**From:** Charlotte Labbett [REDACTED]  
**Sent:** 18 February 2021 17:07  
**To:** Planning <[planning@oxford.gov.uk](mailto:planning@oxford.gov.uk)>  
**Subject:** Objection to 20/00934/FUL

Please see below and attached my objection to the planning application 20/00934/FUL

I am writing as the owner of The George Public House, 5 Sandford Rd, Littlemore, Oxford OX4 4PU.

Issue Date:	Scale:	Drawn:	Check:
22.07.2020	1:200 @ A1 @ A3	JR	JC
Job No	Disc.	Type	Number Revision
190277	A	ST	004 C

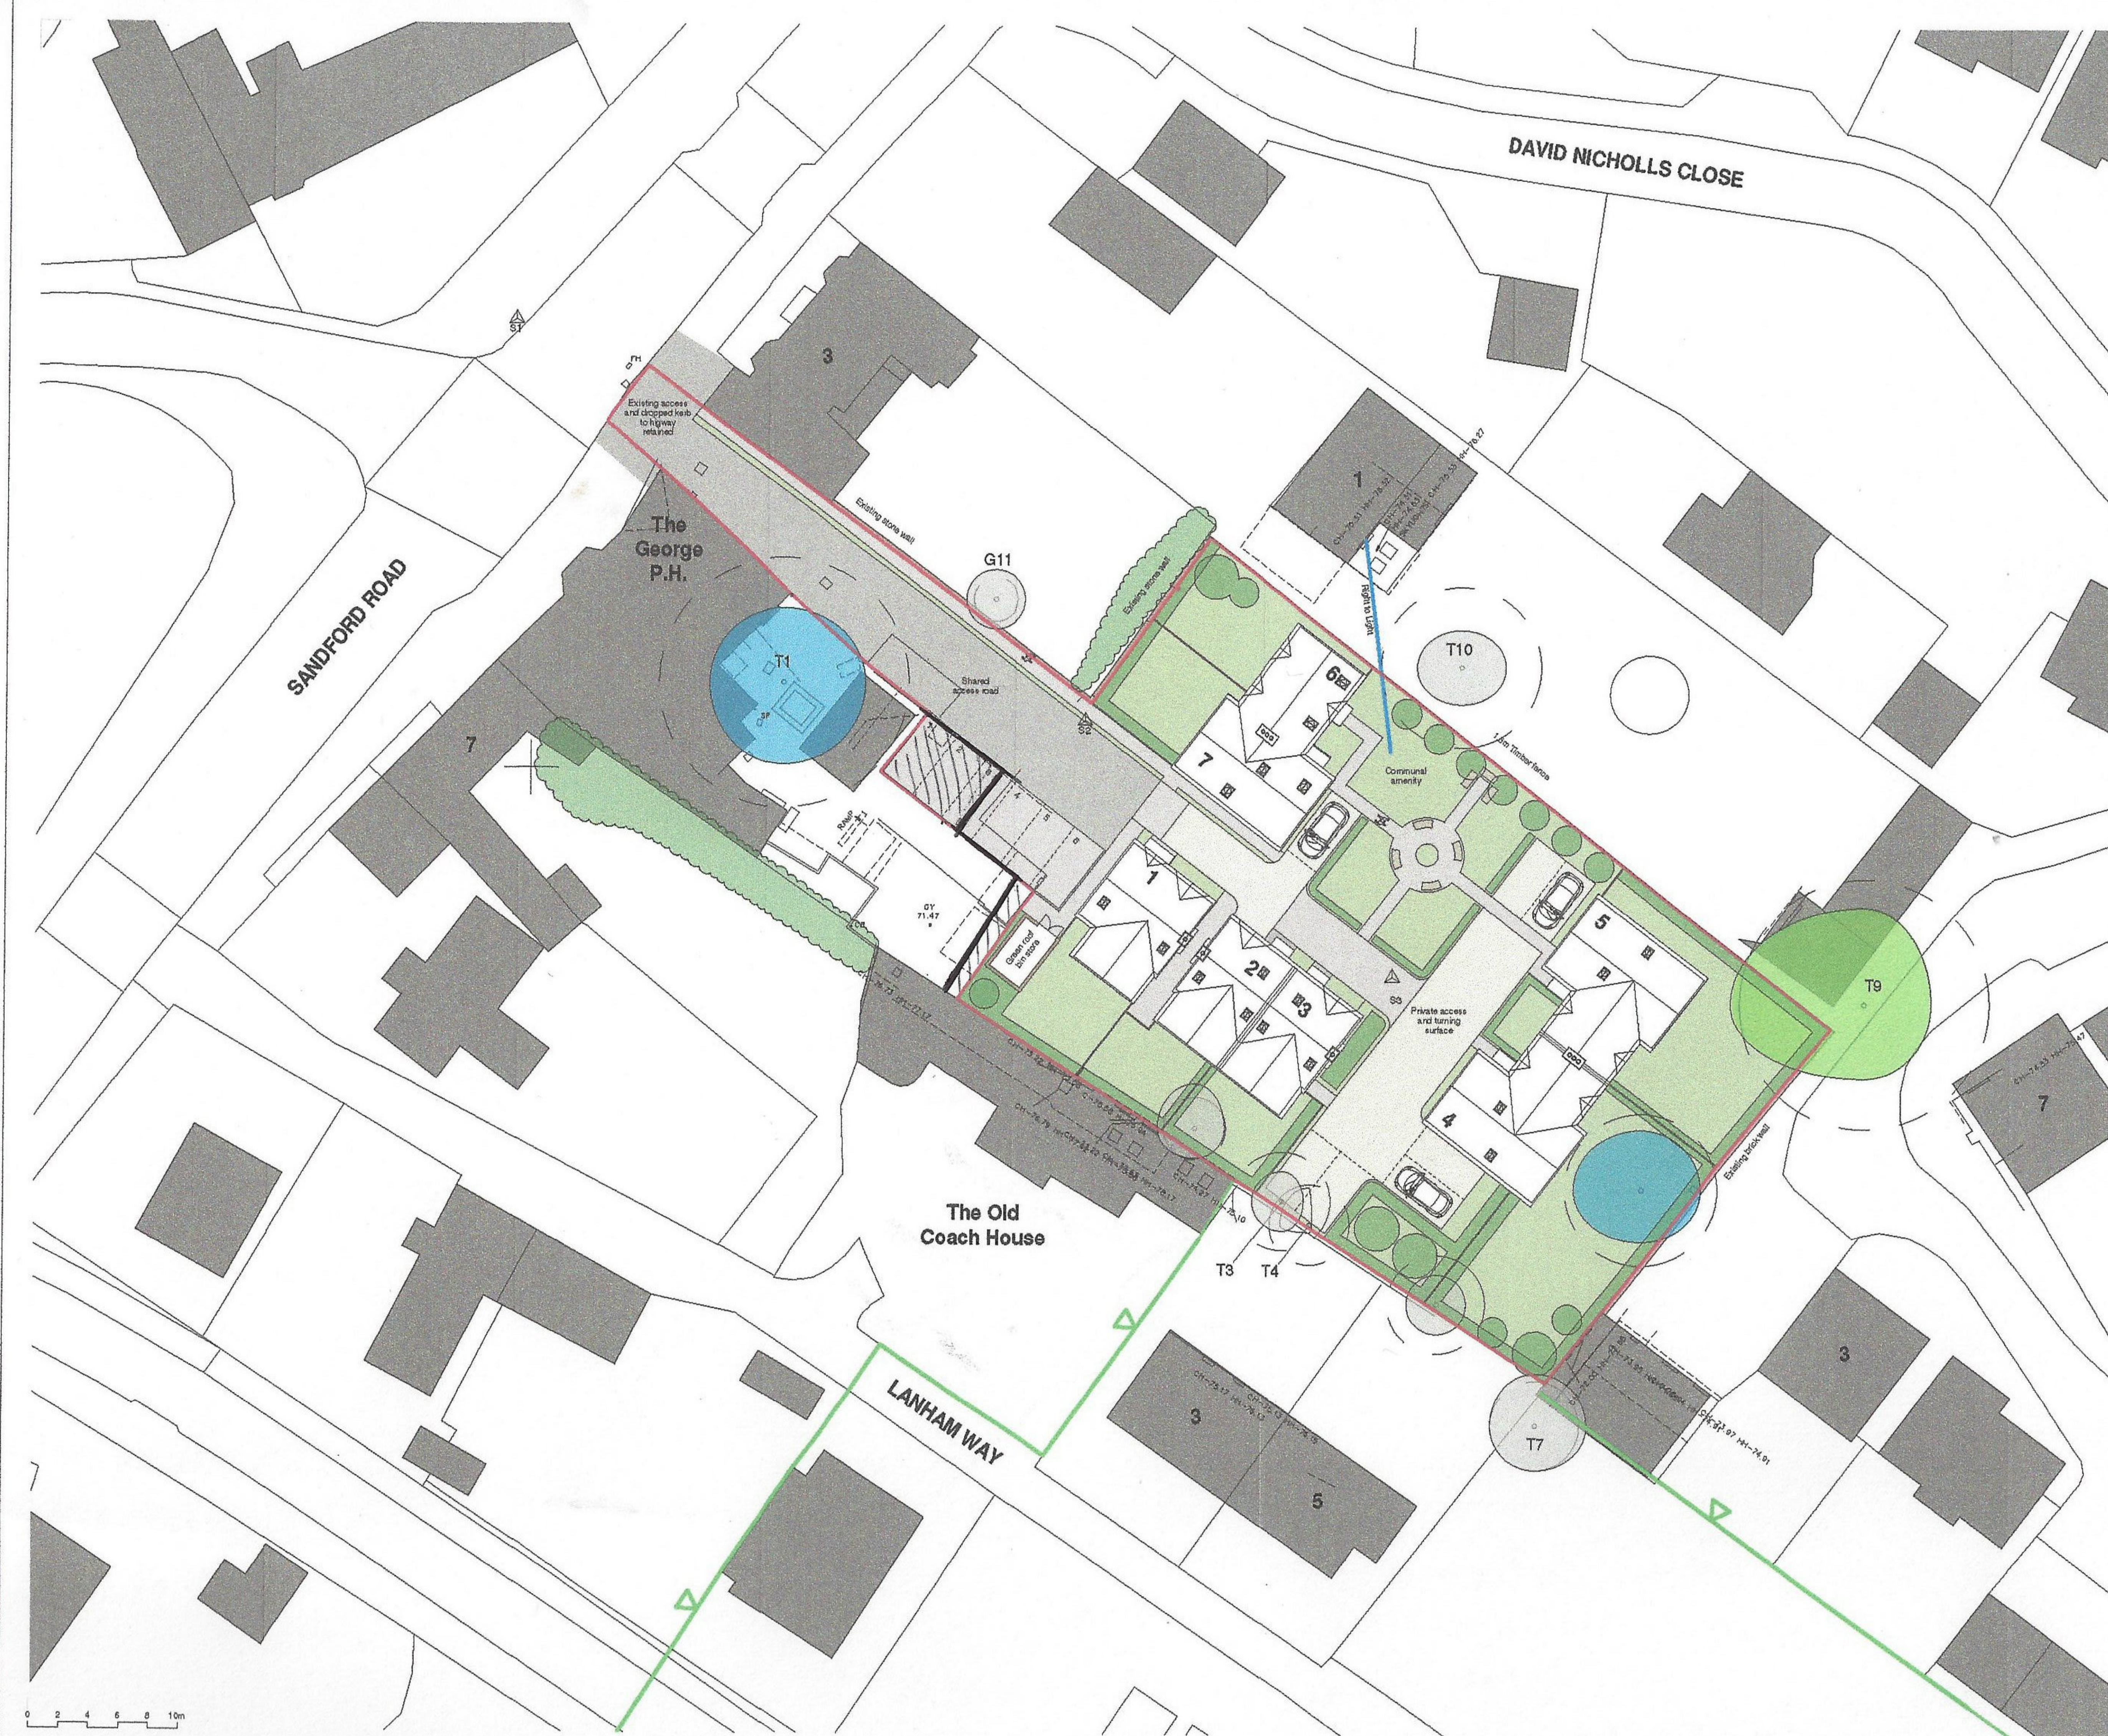
He is suggesting he is putting in a wider access road than he is allowed to do as part of his planning application. He has shown a road that is 7.3m wide but he has only purchased a road of 6.9m wide at its widest point. I attach the plan of the land sold to the developer which shows clear measurements.

Where he has currently sited the bin store and cycle rack it is on our land. This is not ideal as people will be dining in our beer garden making it unhygienic and smells will be coming from bins and even if he were to move them back onto his land, we would require some form of separation from our beer garden and his bin store i.e a 2m wall or fence. Application is currently unimplementable in its current form.

He also shows a grass verge mid way up the access road on the right hand side next to the bin store which runs across what is our rear and fire exit to the pub. This is also partly shown on our land and would create a slip/trip hazard in the case of an evacuation.

Where the parking spaces for the pub are now shown our right of way doesn't extend far enough back to service those spaces which would make them unusable for the pub and therefore the application would not conform with policy stating the requirement for the pub to have 6 useable spaces.

We have today had a constructive site meeting with the applicant and he has informed us that he will amend the plans to deal with these issues mentioned above and extend the right of way up to the parking spaces. Should this be done and amended plans submitted we are prepared to withdraw the objection and will keep you informed of matters.
